From:
Sent: 28 October 2025 19:37
To: Louise Bearcroft; DC Admin
Subject: Objection-Kirklees Planning Applications: 2025/44/92737/E

Re: Kirklees Planning Applications: 2025/44/92737/E and 2025/61/92713/E

Site address: Rear of, 23 to 43, Moor Lane, Gomersal, Cleckheaton, BD19 4LF

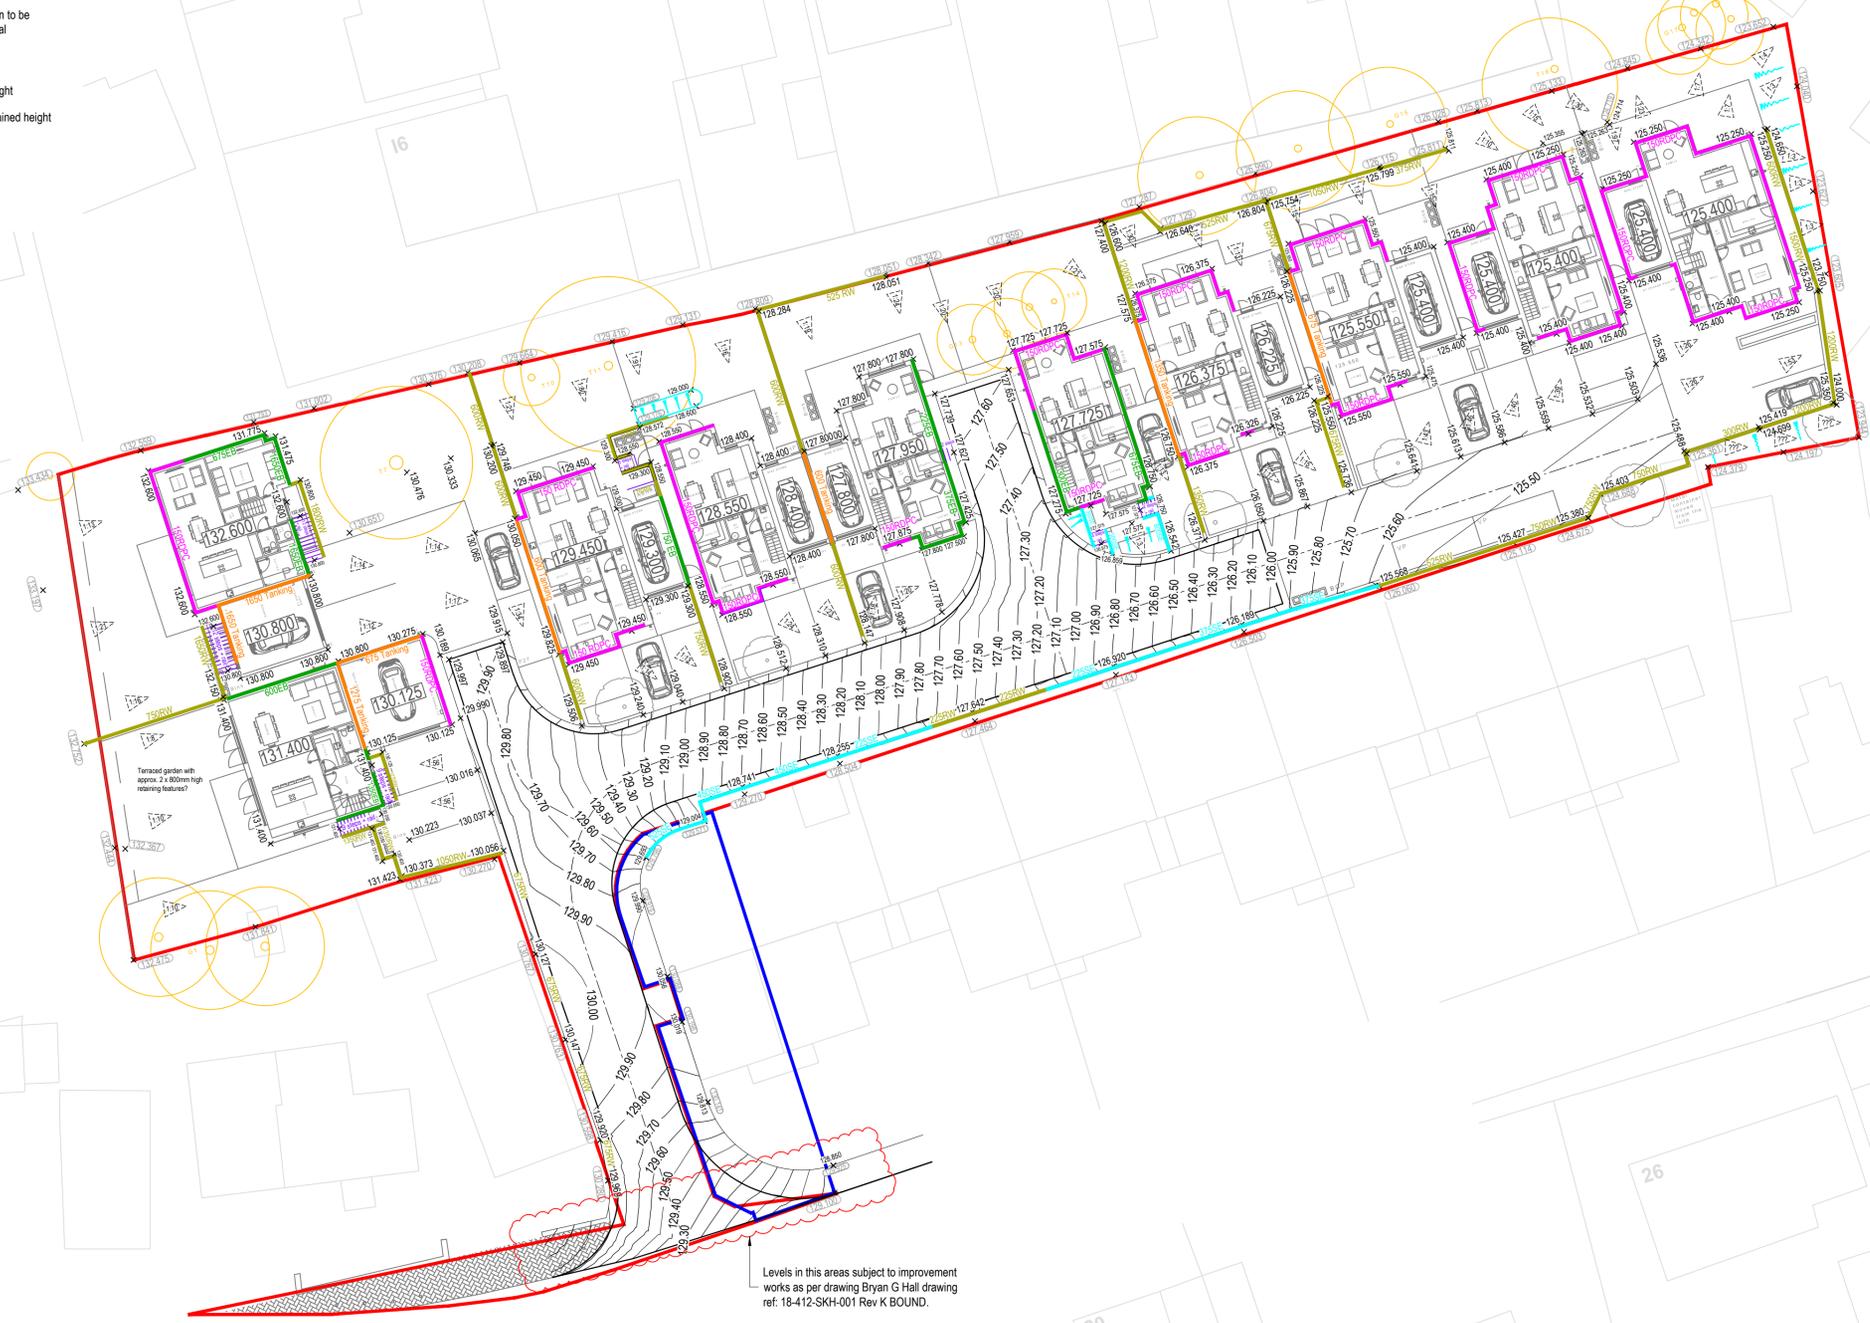
If the drainage plans are up to the required standard, then why does the developer feel it is necessary to 'Tank' certain walls on these new build houses? 6 out of the 10 proposed houses, at the top end of the site, are shown, on the Levels Plan, as being built having tanking installed. As these new build houses are all above ground level, why is tanking being used to stop water ingress to make them waterproof? Tanking is normally used in wet and damp cellars and very old buildings, generally not on new builds. If tanking is deemed necessary, then this seems to confirm that surface water is going to be a problem and logically it's going to flow downhill and across the site following the gradients.

**Private Drainage**

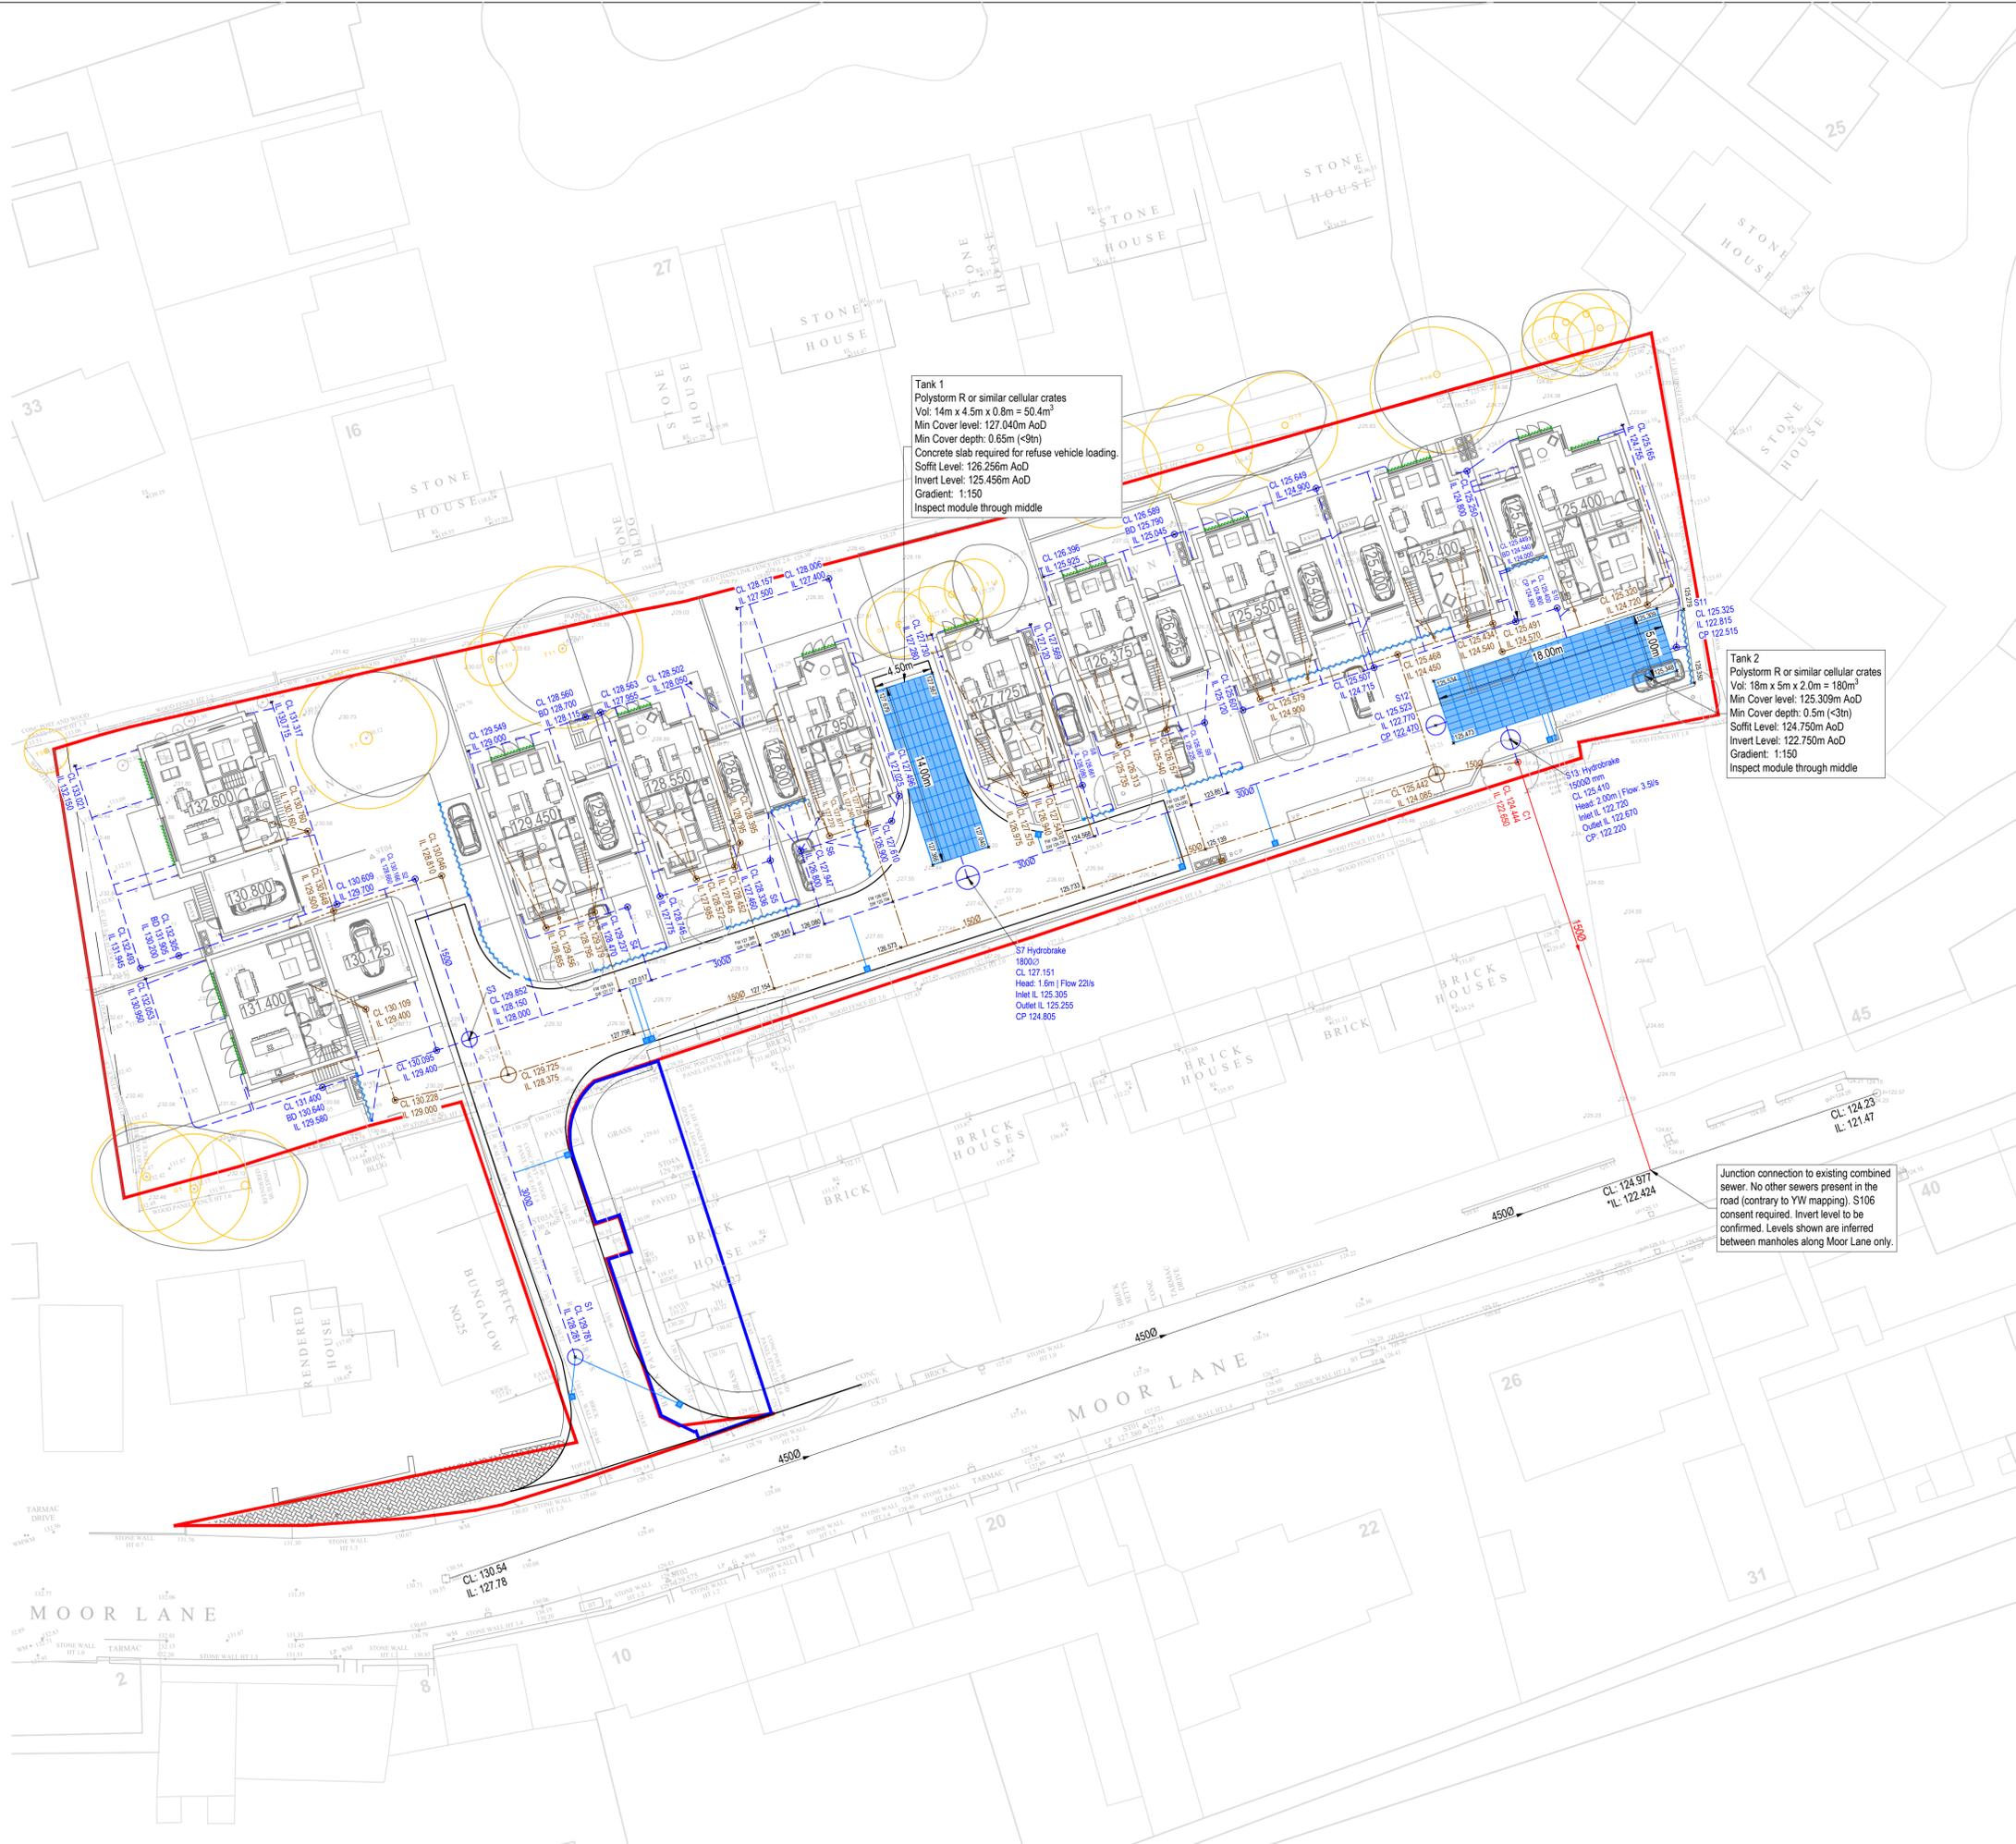
The current drainage plan show some kind of plastic crates located in two locations. The builder is channelling surface water down, through the site via these crates, towards existing residential properties. A new single 6 inch pipe will then carry both surface water and foul sewerage water, together, to a Yorkshire Water's drain in Moor Lane. We are extremely concerned as to whether this single 6 inch pipe will have the capacity to carry both the foul sewerage and the surface water, together, from this major development. Failure of this pipe will be catastrophic for all the residents in the local vicinity.

This drainage system plan does not meet Yorkshire Water stipulation specified in their consultation letters regarding this site. Two of their letters, Y.W. Ref: Y013884 and Y005783, both state: "The site shall be developed with separate systems of drainage for foul and surface water on and off site." (Both of these, on Kirklees Planning Website).

This developer is removing surface water and foul sewage from this site via one 6 inch single pipe, so is not complying with Yorkshire Waters conditions.

In a box on the Drainage Plan. This states: **"Junction connection to existing combined sewer. No other sewers present in the road (contrary to YW Mapping). S106 consent required. Invert level to be confirmed. Levels shown are inferred between manholes along Moor Lane only."**

It does not seem logical, that Yorkshire Water does not know its own mapping, C Roberts, YorMap, 87 2582, supporting document from Yorkshire Water, clearly shows two pipes in Moor Lane. Therefore this brings into question whether the developer's statements and knowledge, on these drainage plans, are viable and correct.

Yorkshire Waters website states "Please note that foul water must not be disposed of to a surface water sewer and surface water should generally not be discharged to a foul or combined sewer." On these drainage plans, the developer is showing just one 6 inch pipe

discharging both foul and surface water via one pipe into one sewer in Moor Lane. Therefore this developer seems to be acting contrary to Yorkshire Waters advice. Moor Lane already suffers from excess water flow on the road during continuous heavy rain and probably the existing drain is already struggling to cope. These drains have already had extra pressure put on them from the 10 apartments recently connected from the Silk Mill conversion on Moor Lane.
